**KIRKLEES METROPOLITAN COUNCIL
INVESTMENT & REGENERATION SERVICE**

Reference No:	2023/62/91316/E
Site Address:	10, Park Close, Shelley, Huddersfield, HD8 8JF
Description:	Demolition of existing garage and erection of single storey side and rear extensions and external alterations
Recommending Officer:	Nicole Helliwell

Officer Report

Client	Mr & Mrs Dolley	Issued From	
Project	2375 : 10 Park Close : Domestic Extension	Date	March 2023
Title	Existing and Proposed Site Plans	Scale	1:100 @ A1
Drawn	BH	Auth	BH

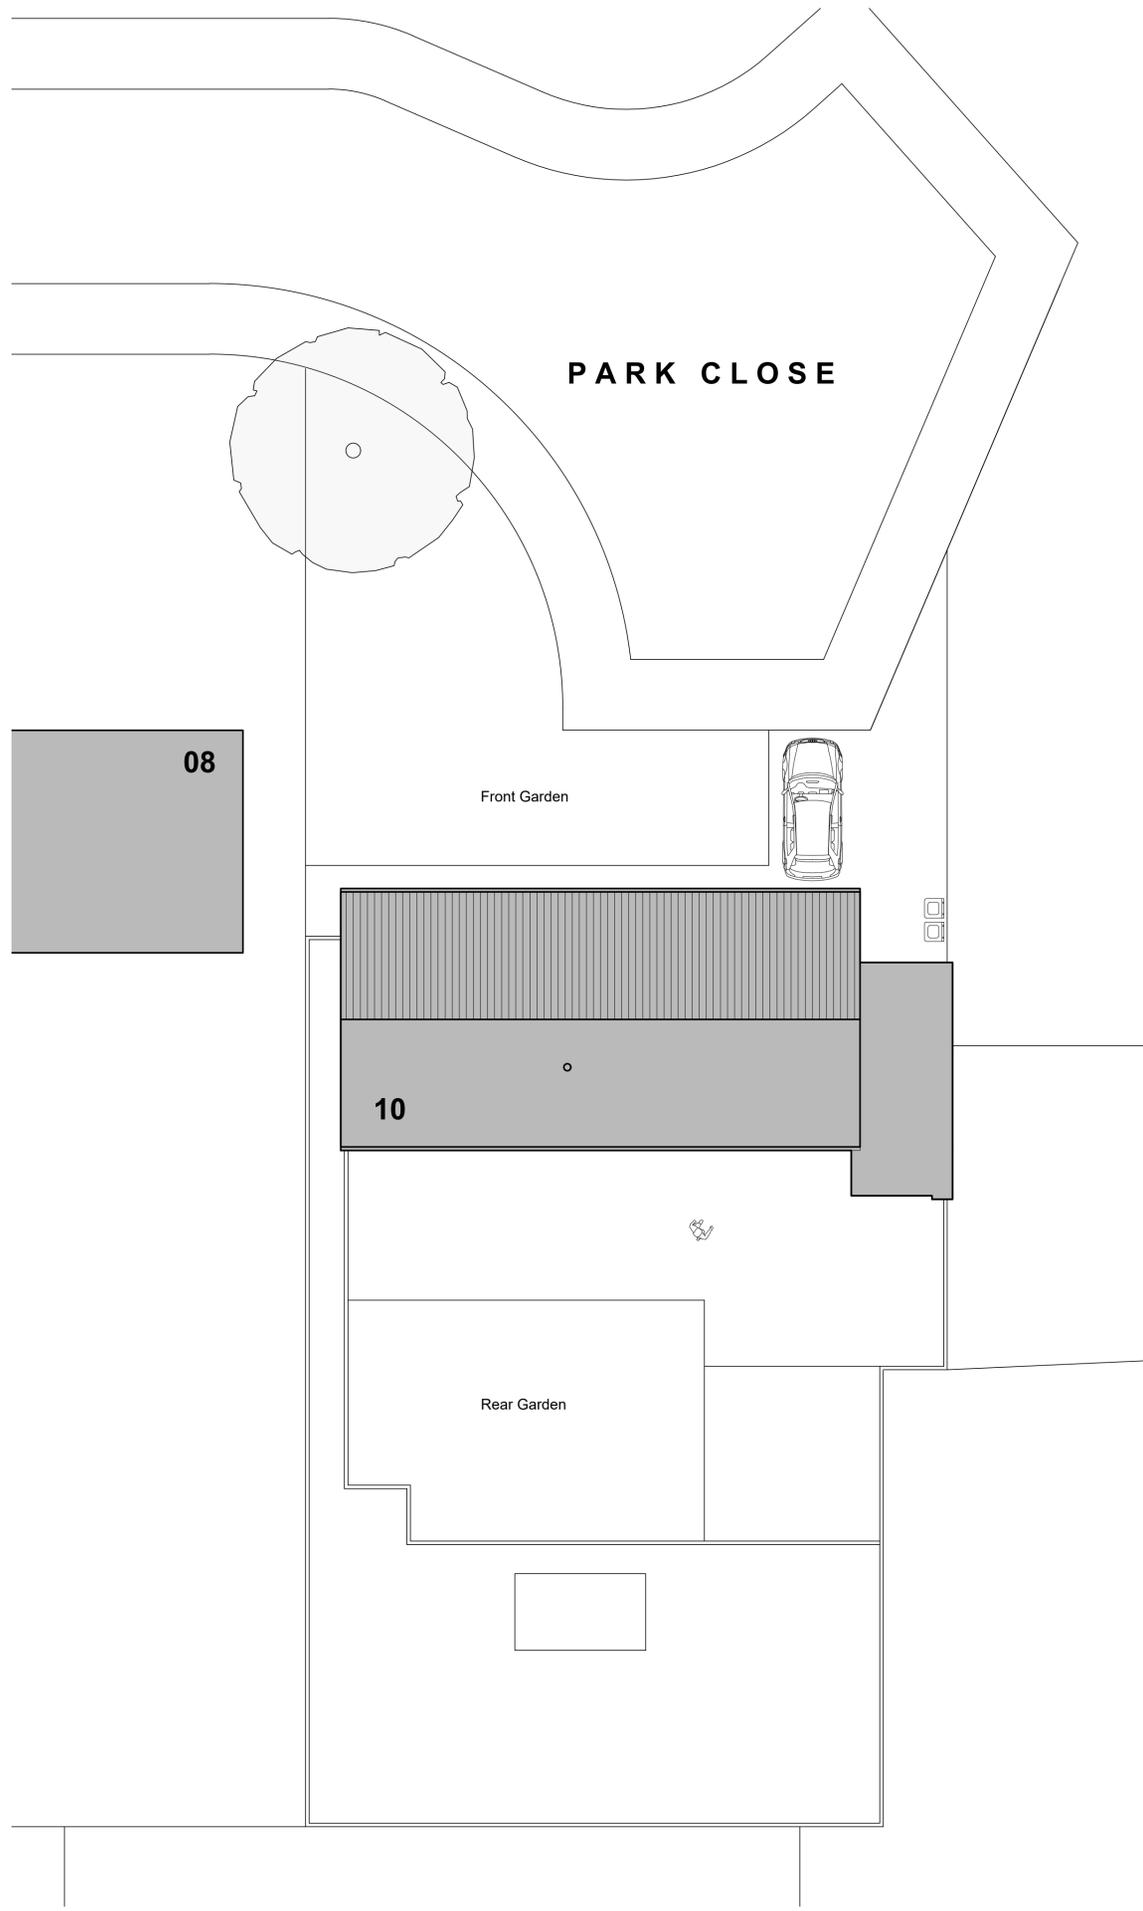
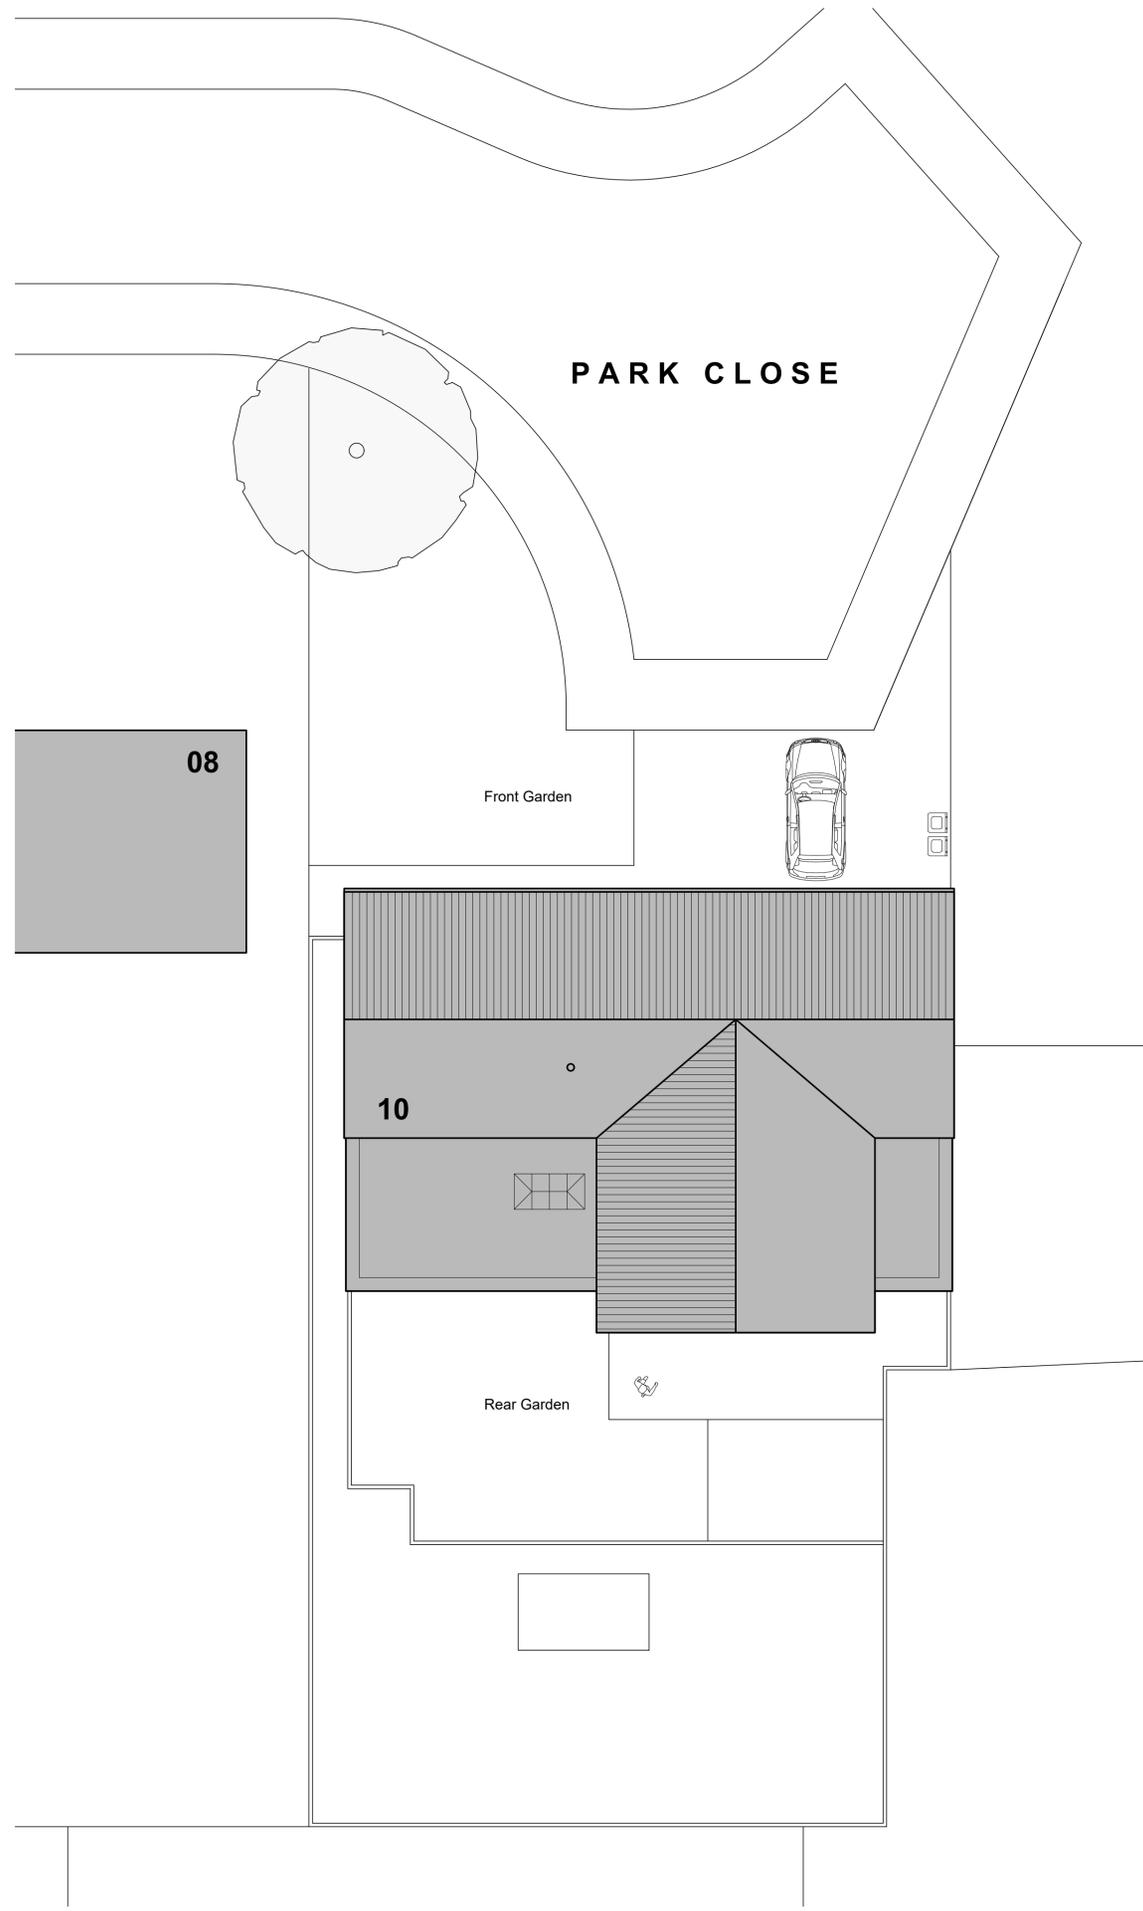
The proposal also seeks to extend the existing parking area north of the application site. Although this would reduce the amount of outdoor amenity space to the front, the proposal would not appear out of character with the surrounding area and would not have a material impact on visual amenity.

The proposal would not intensify the domestic use at the property but would affect the existing parking arrangements on site. However, the plans confirm that at least two off street parking spaces would be retained on site which is considered to represent a sufficient provision for a three bedroomed dwellinghouse. Therefore, the proposed development is considered acceptable in accordance with Policies LP21 and LP22 of the KLP, Chapter 9 of the NPPF, Principles 15 and 16 of the Kirklees House Extensions and Alterations SPD and the Highways Design Guide SPD.

Comments also expressed that there are inconsistencies with the boundary line shown on the submitted plans. However, a revised location plan was submitted to address this discrepancy along the north eastern boundary and was considered acceptable.
